CITY OF PORTLAND
DEPARTMENT OF PLANNING & URBAN DEVELOPMENT

Inspection Violations

Owner/Manager STEPHENS CLARK B		Inspector Peter Merrow	Inspection Date 01/27/2006
Location 198 SPRING ST	CBL 045 F026001	Status	Inspection Type Complaint-Inspection

SIDING PLAN

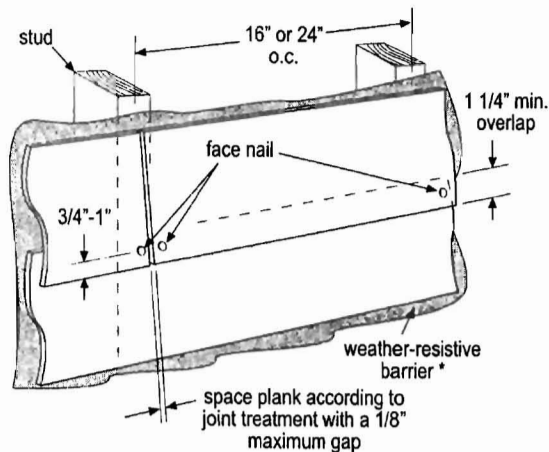
Code	Int/Ext	Floor	Unit No.	Area	Compliance Date
1) 6-108.1	Exterior			entire	
Violation: Foundations cellars, exterior walls, roofs					
Notes: No siding or vapor barrier around building. Must be finished in 30 days
